From: Simon Davis
Sent: 17 March 2021 18:20
To: Planning Scanning
Subject: FW: Y/146/20/RES - Land at Street Buildings, North End Road, Yapton

From: Simon Davis <Simon.Davis@arun.gov.uk>
Sent: 17 March 2021 14:15
To: Tilly Whishaw [REDACTED]
Subject: RE: Y/146/20/RES - Land at Street Buildings, North End Road, Yapton

Title:
PLANNING LAYOUT

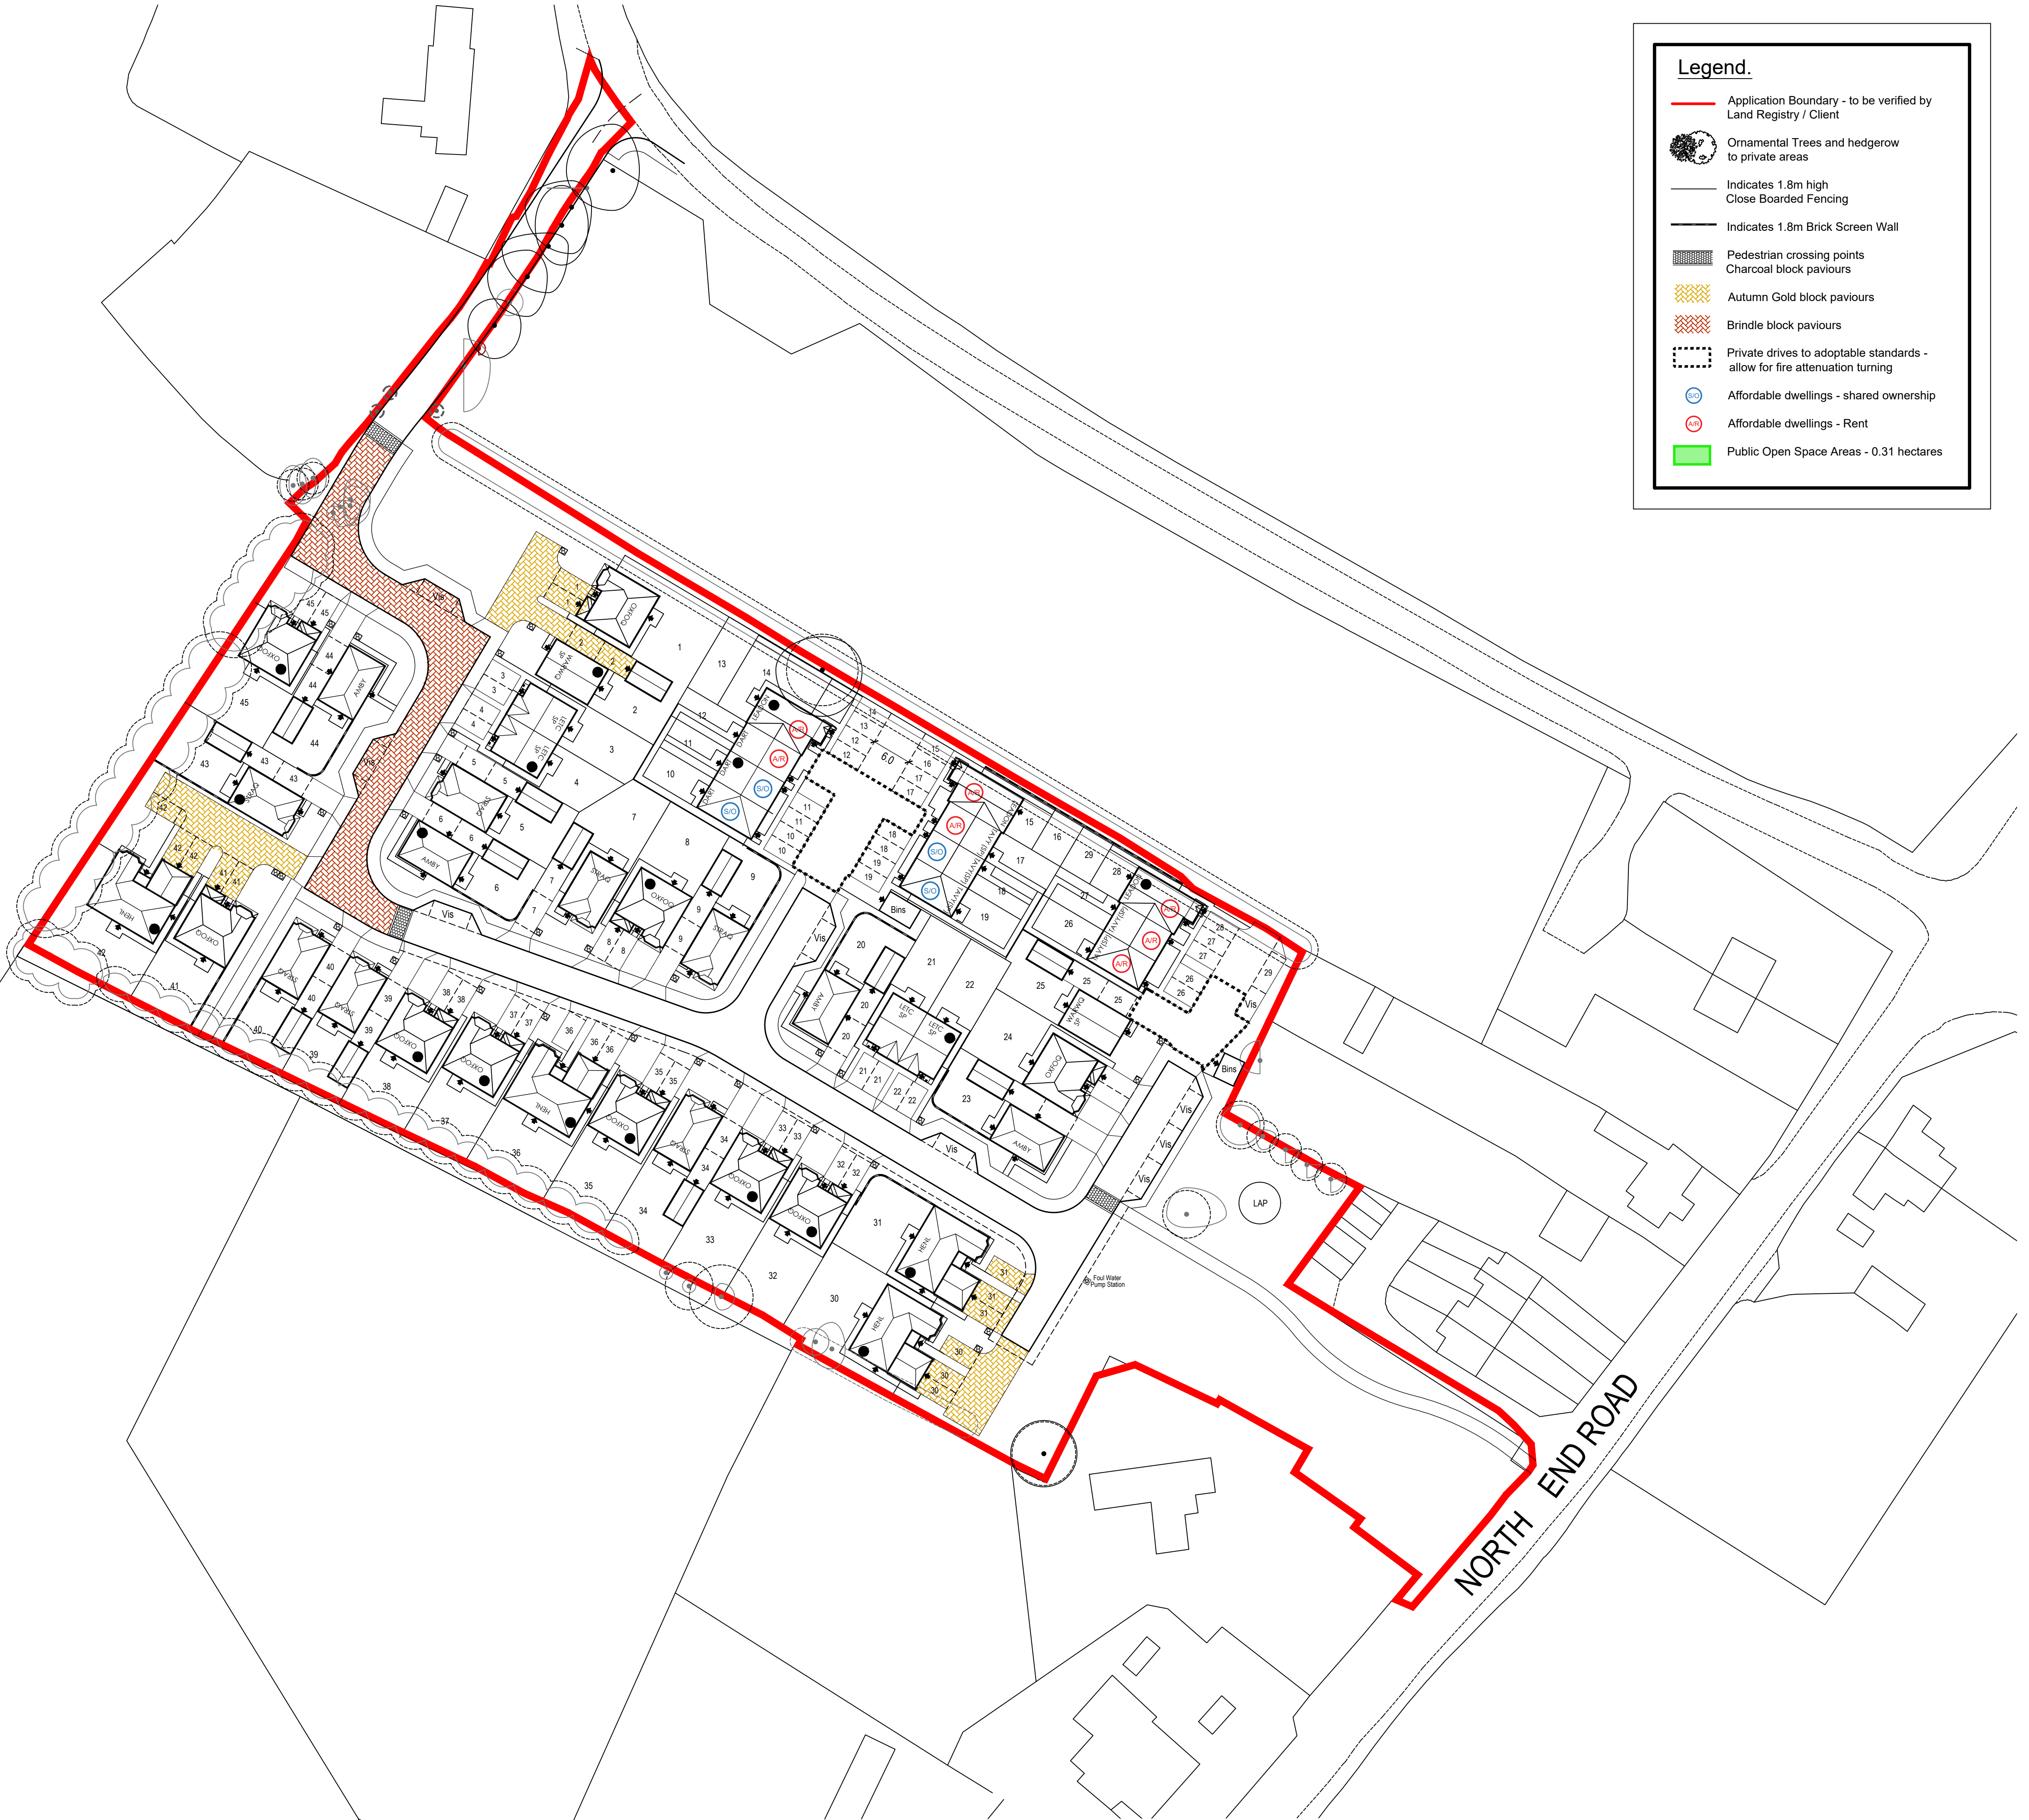
I can't see any information in the submission as to which units are to be M4(2) compliant. There are 17 black dots on the layout plan but they are not on the key. Is this them or is it only certain house types? Please can you advise.

As with the previous application there are no set dwellings for the M4(2) compliance, however the following house types meet M4(2):

- * Leadon
- * Tavy
- * Oxford Lifestyle.
